Project # 1006606

Project Name: Video Adn.

M E M O

Re: Project #1006606, SDP Building Permit – Burger King on Eubank SE

SHEET TITLE
SITE UTILITY PLAN

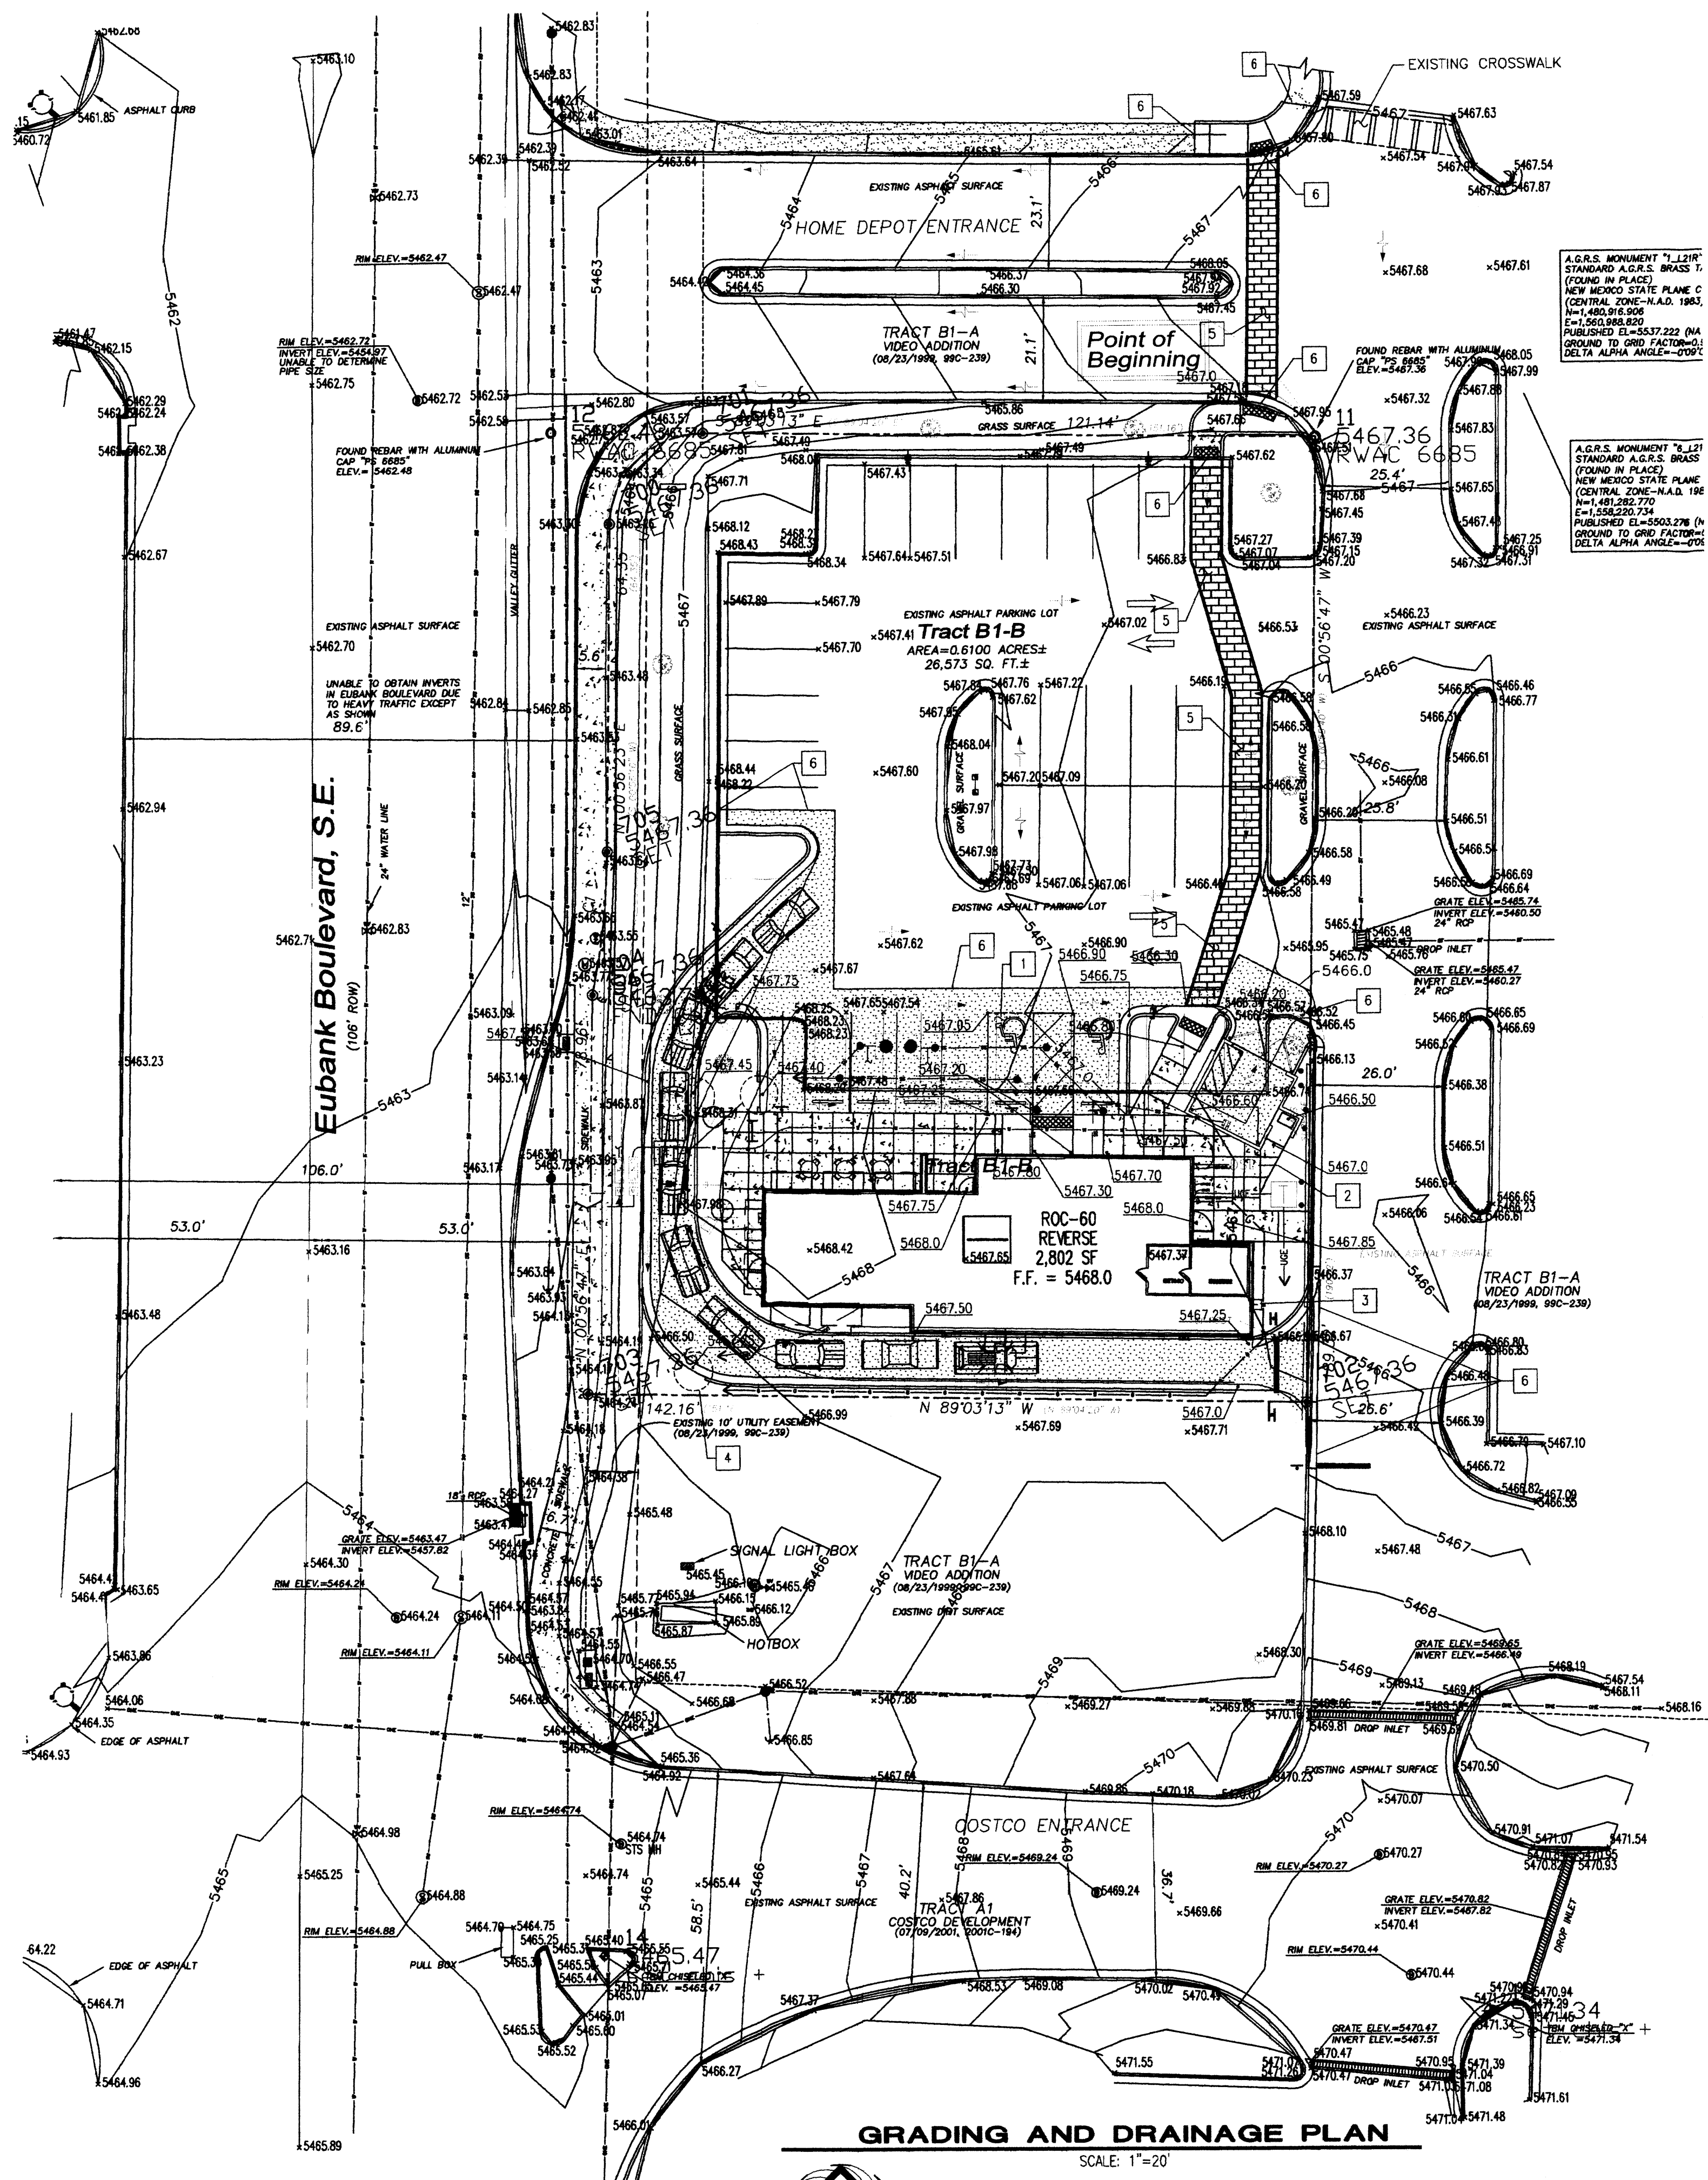
UTILITIES: - revise Utility Plan

- The scale on all plan sheets is slightly off, i.e. 1" = 19.5' instead of 20'.
- Reinstate sequential sheet numbers as per the EPC submittal, i.e. sheet 1 of 7, etc.
- Delete traffic control note 17 as it appears to be a duplicate.
- The site layout on the utility and the grading & drainage plans needs updating.
- Some of the data (spot elevations, etc.) on the grading & drainage plan are not legible.
- The plan detail of the refuse enclosure on sheet C7 has the side opening facing the wrong direction. It should face southeast as shown on the site plan (C2)

PROJECT TITLE: 200 EUBANK BLVD. S.W.C. OF EUBANK AND CENTRAL ALBUQUERQUE, NEW MEXICO
 PROJECT NUMBER: JOB NO. 200 EUBANK
 DRAWN BY: S
 SHEET TITLE: LANDSCAPE PLAN

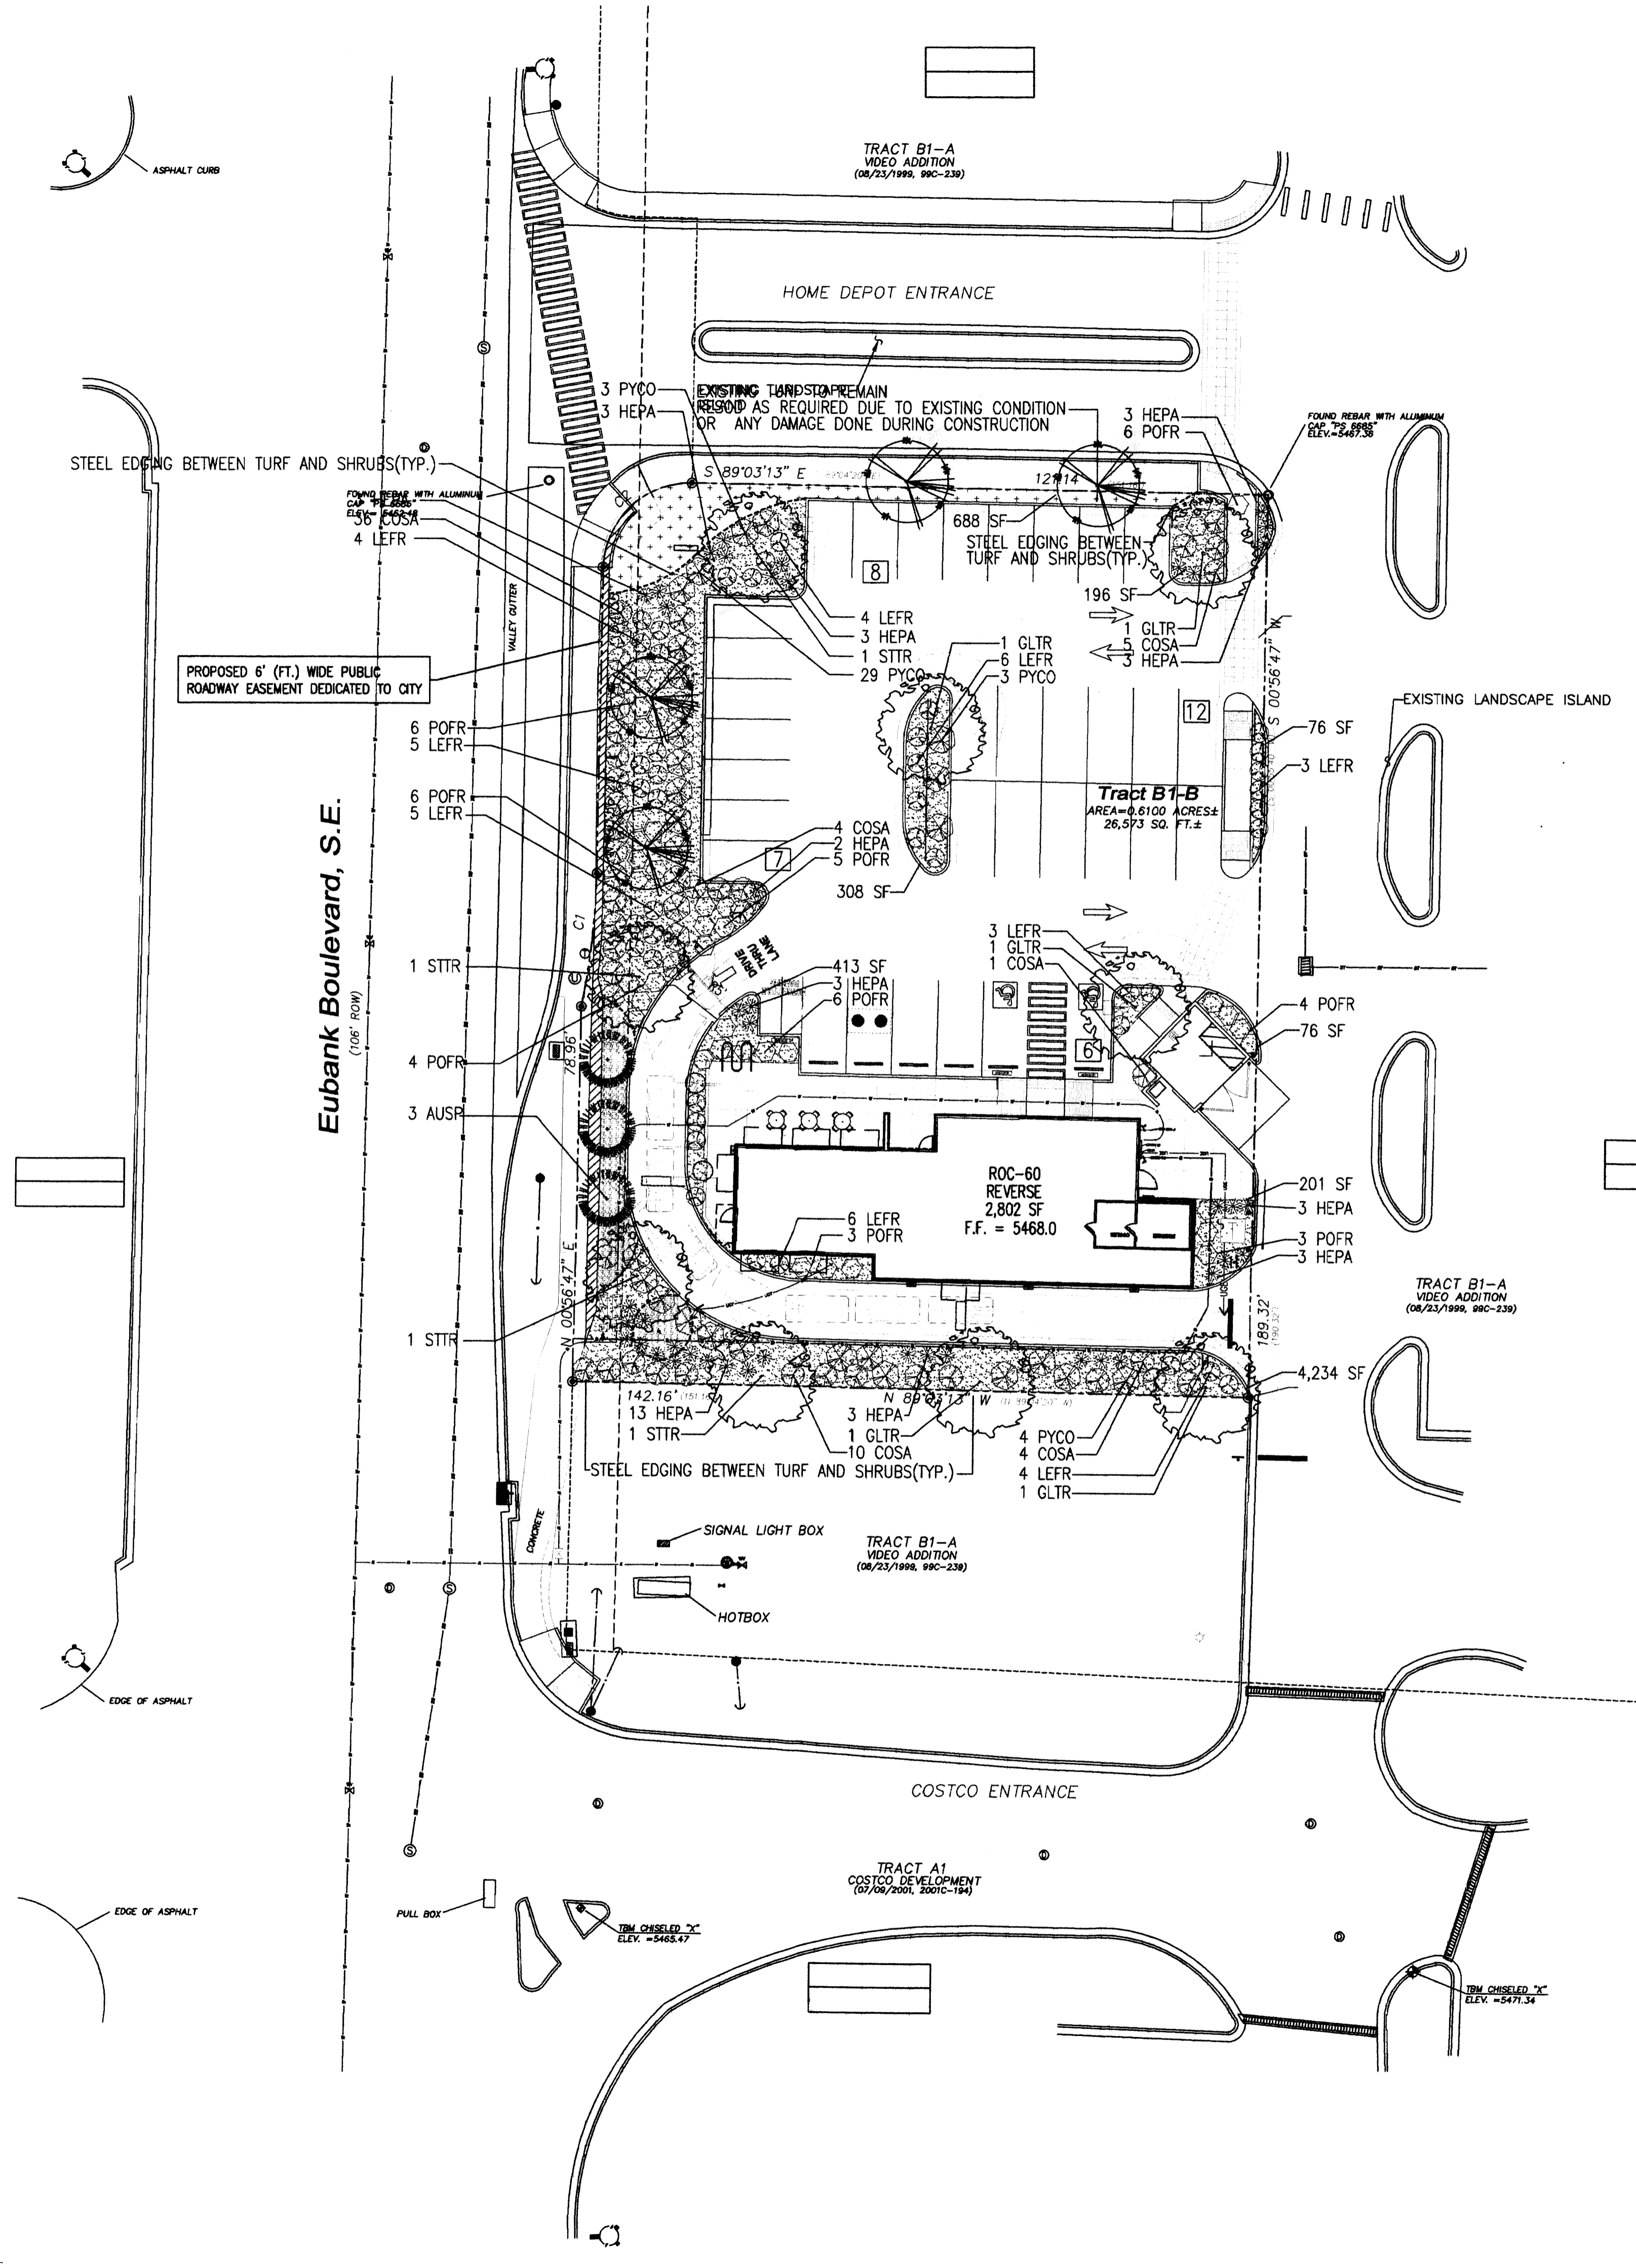
- #7.d – Replace the shrubs in the landscaped bed at the east edge of the site between the two site drives with a shade tree and evergreen ground cover (i.e. low plant).

- #11.a.ii – Since the refuse enclosure was rotated, the shrubs on the *northeast* need to be evergreen.
- #11.c – Evidence that Home Depot is not allowing landscaping to the south has not been received.

- #11.d – The curb cuts need to be keyed or labeled on the landscape plan. Also, curb cuts can be added to other parking end islands/caps.
- #11.e – Not met. Also, reinstate symbols and whether plants are evergreen or deciduous.

- #11.f – not met.
- #11.g – Include organic mulch.
- #11.h – not met.
- #11.i – Coordinate with #6
- #11.j. – i. Not met.
 - ii. Street trees must be placed less than 20' from ROW and have 2" caliper. Revise street tree calculations.
 - iii. Do Austrian pines conflict with PUE on Eubank Blvd.?
- #12 – Missing from cover letter. Staff planner delegates review to the DRB.
- #13 Electrical utilities – Applicant's response does not apply. Staff planner delegates review to the DRB.
- #14.a – Information on materials, colors and illumination are not provided for sign details 3, 6, 8 and 9 on sheet C7.
- #14.b – References not provided for traffic signs 8, 9 and 11, and for drive-thru signs 14, 15, and 16.
- #14.d – Not shown.
- #15 – Not met.
